**Consultation Response from KC,
Highways Development Management****2022/93245 adj, Marsh Conservative Club, Abb Street, Marsh, Huddersfield, HD1 4PB****Erection of two semi-detached dwellings****Date Responded: 7-12-2022****Responding Officer: Mark Berry****Responding Ref: 5-2SE-61**

This application seeks approval to the erection of two semi-detached, two bedroomed dwellings at land adjacent to Marsh Conservative Club, Abb Street, Marsh, Huddersfield.

1 Proposed Site Layout
1 : 200

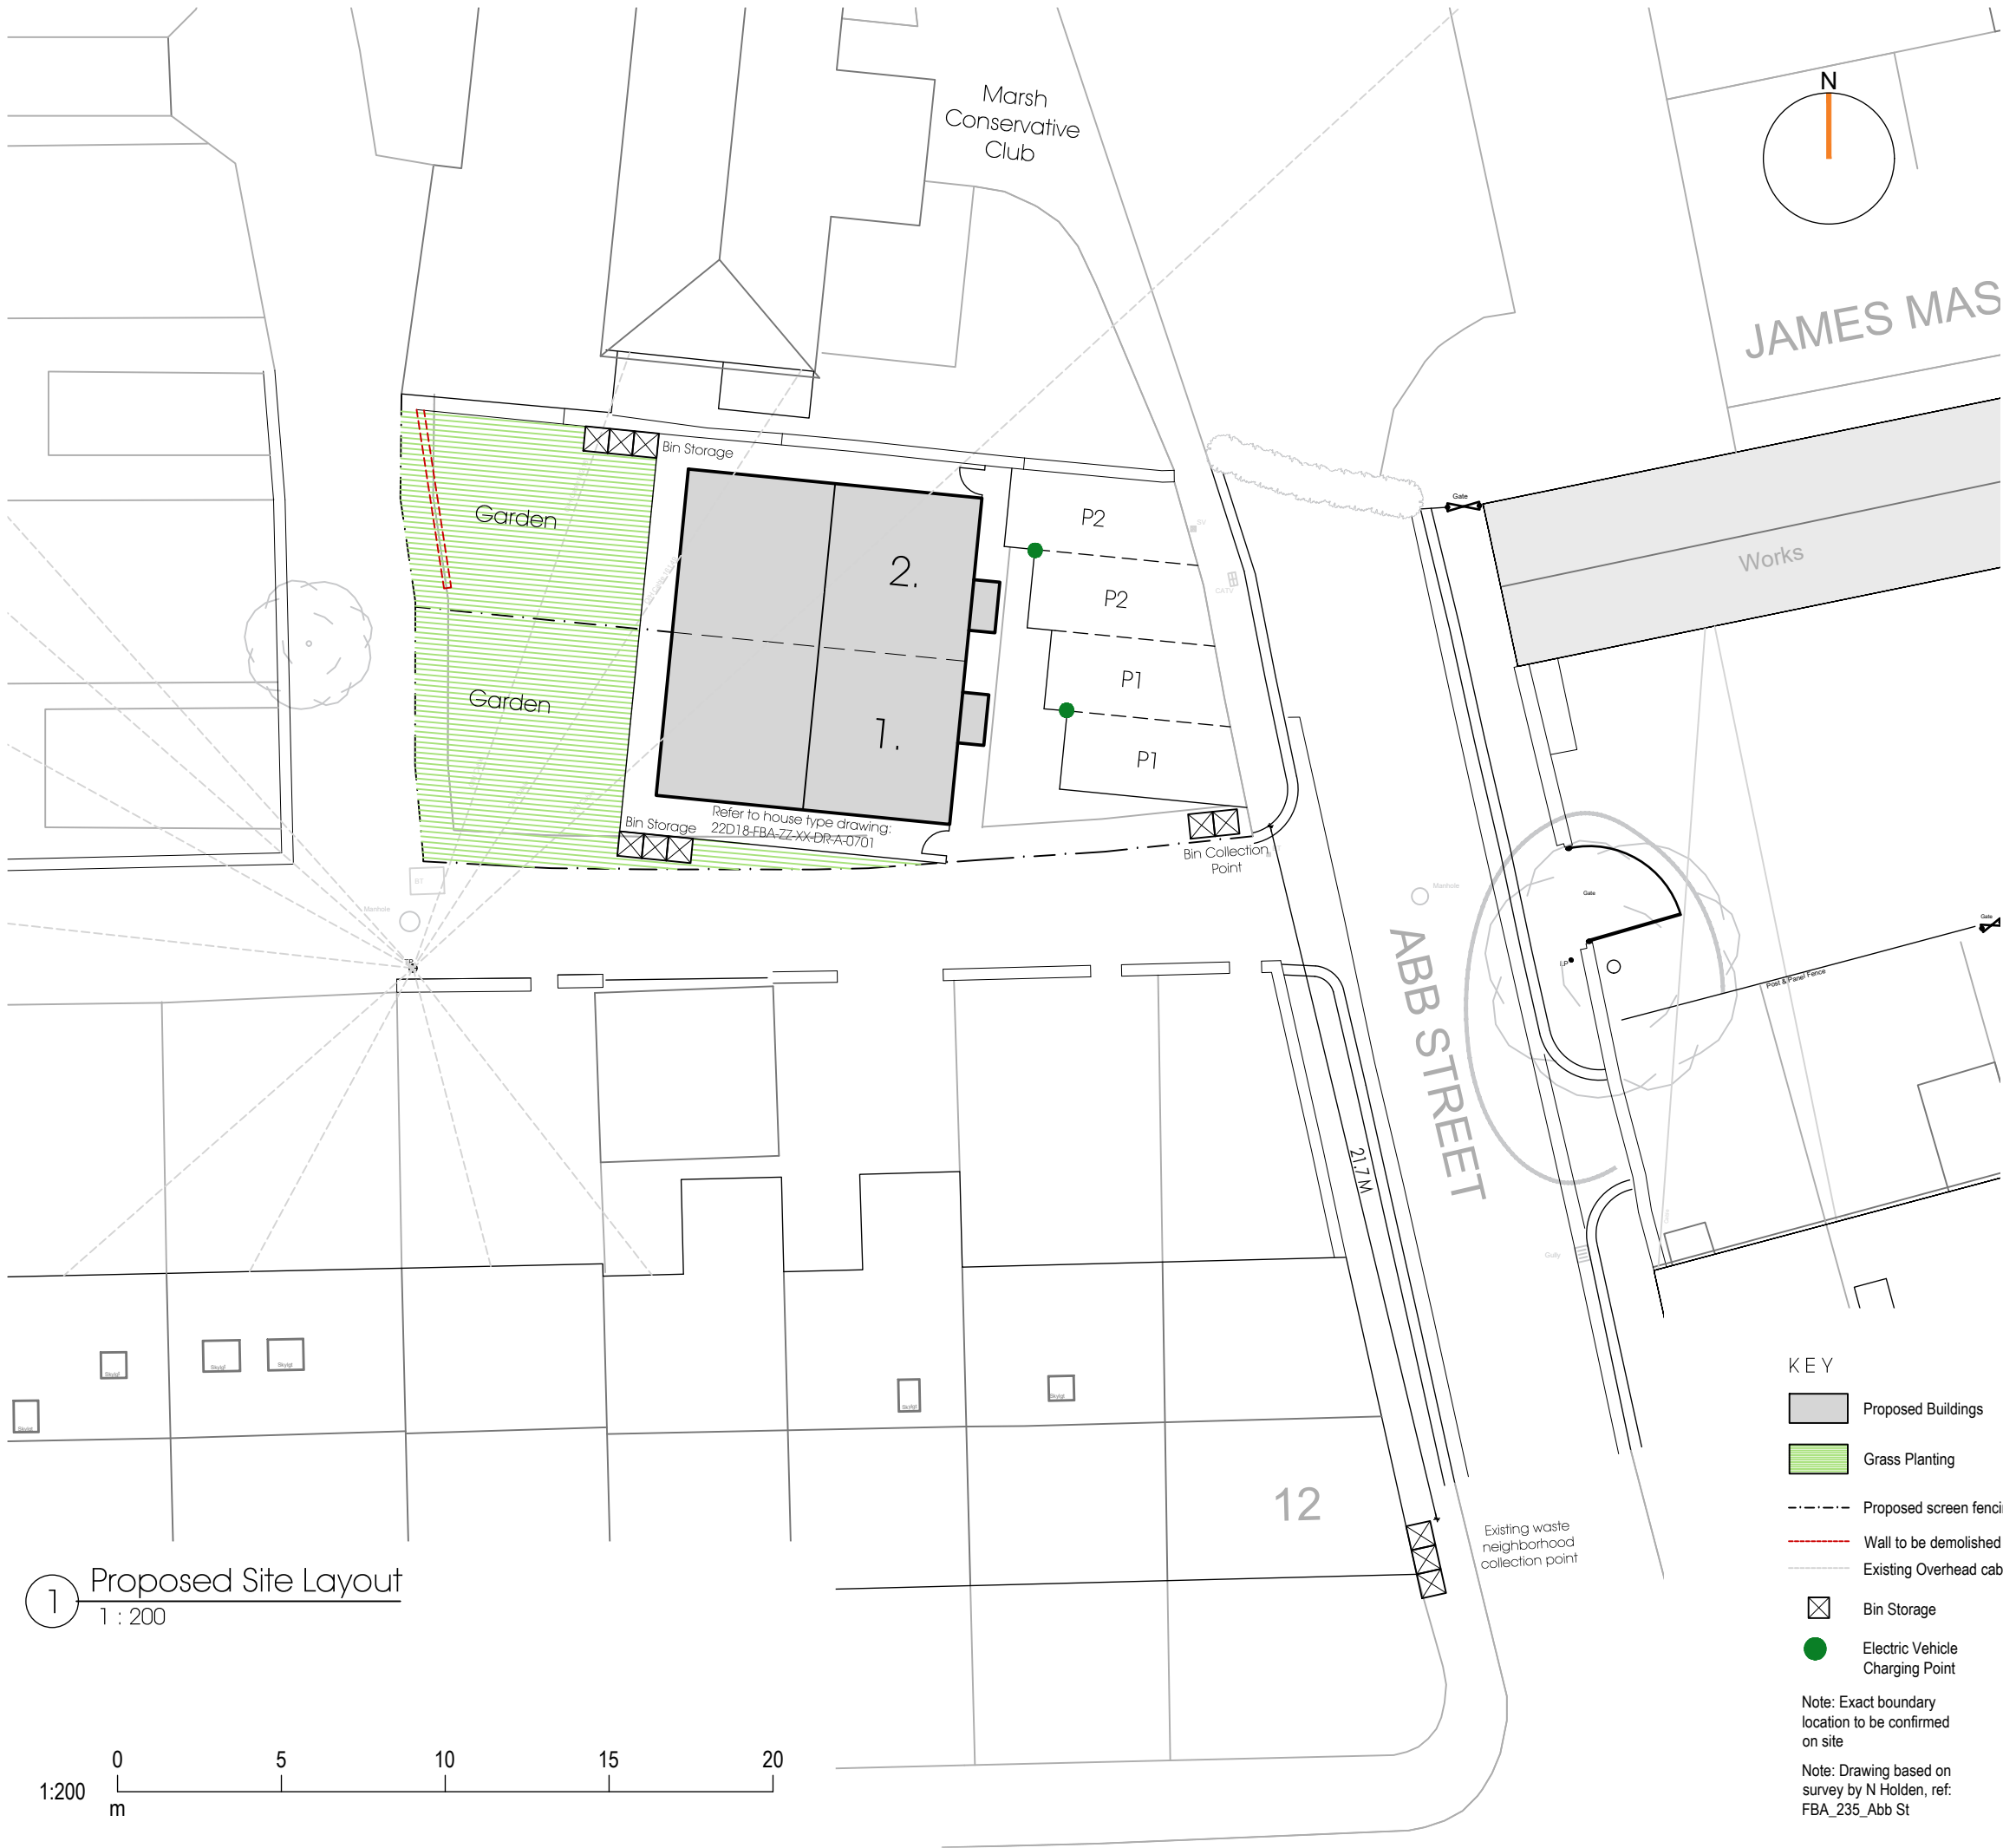
Access to the northern parking space to plot 2 is however not from the existing tarmacked section of Abb Street. Access in to this space is poor and will require difficult turning and manoeuvre. Can the applicants explain how access to this parking space is to be achieved.

Bin collection points should be shown to be provided to both dwellings to enable bins to be presented on collection day without either obstructing the highway or proposed driveways.
